South Humber Bank Energy Centre Project

Planning Inspectorate Reference: EN010107

7.7 - Statement of Common Ground with Network Rail

Applicant: EP Waste Management Ltd
Date: December 2020

**Figure 3.1: HGV designated route plan**

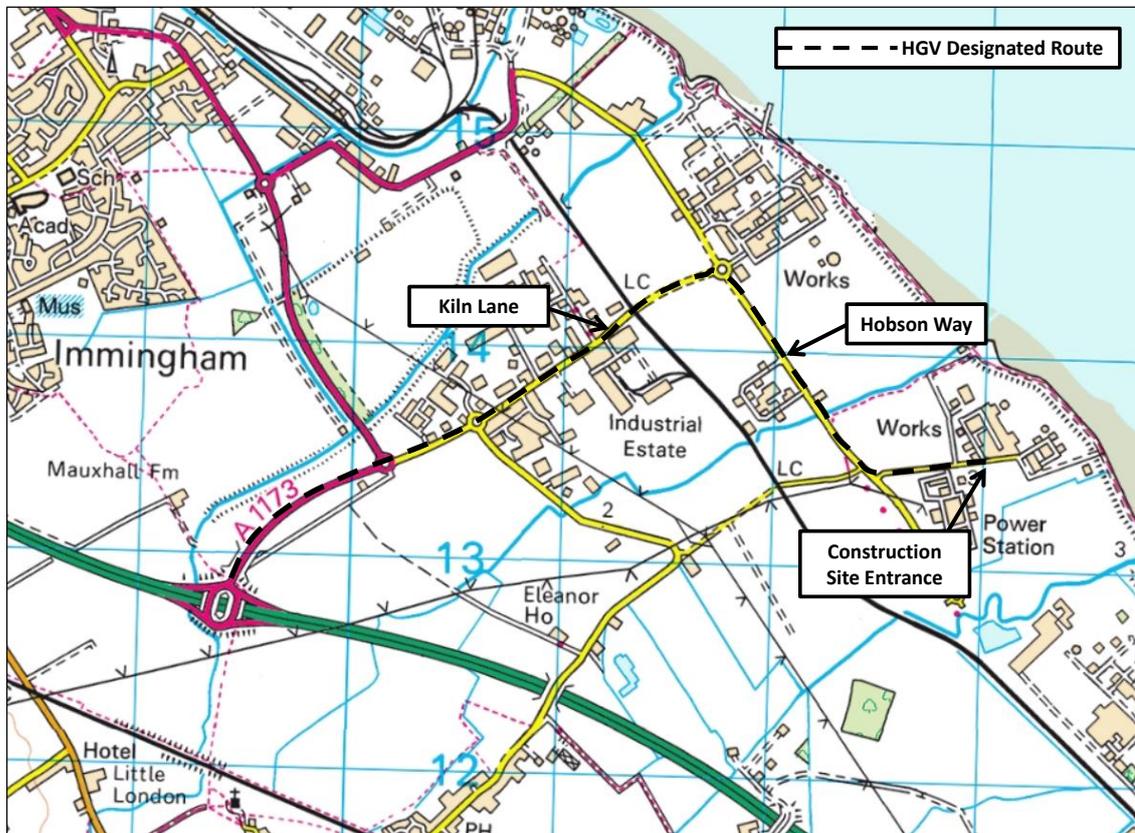
21 September 2020	<p>Network Rail provided a written objection to the Applicant by email as follows:</p> <p><i>"Network Rail objects to the proposed routes from the road infrastructure to the proposed location of the South Humber Bank Energy Centre. This is on the grounds of significant increase to traffic, specifically Heavy Goods Vehicles, as noted in your document 'Annex 23_ES VOL III Appendix 9A - Traffic Volumes over Kiln Lane LC' and 'EN010107-000241-SHBEC DCO - 6.4.12 ES Vol III Appendix 9A Transport Assessment File 1 - Main Document (1)'. Whilst we note that a baseline traffic survey has</i></p>

16 October 2020	The Applicant submitted a technical response to Network Rail’s objection (see copy in Appendix A).
6 November 2020	<p>Network Rail submitted an updated note of technical detail to the Applicant on 6 November 2020 and responded as follows:</p> <p><i>“Network Rail objects to the proposed routes to the location of the South Humber Bank Energy Centre. This is on the grounds of significant increase to traffic, specifically Heavy Goods Vehicles as noted in your documents ‘Annex 23_ES VOL III Appendix 9A - Traffic Volumes over Kiln Lane LC’ and ‘EN010107-000241-SHBEC DCO - 6.4.12 ES Vol III Appendix 9A Transport Assessment File 1 - Main Document (1)’. This document provides technical information outlining why the proposed routes are unsafe, what is required to make the proposed routes safe and justifications as to costs.</i></p> <p><u>ALCRM modelled risk values for level crossings</u></p> <p><i>The traffic movements from your projections have been added to the baseline model scores for each level crossing. These are the ALCRM⁽³⁾ modelled risk values for each crossing:</i></p> <p><i>Marsh Lane - Double Yellow⁽¹⁾</i></p>
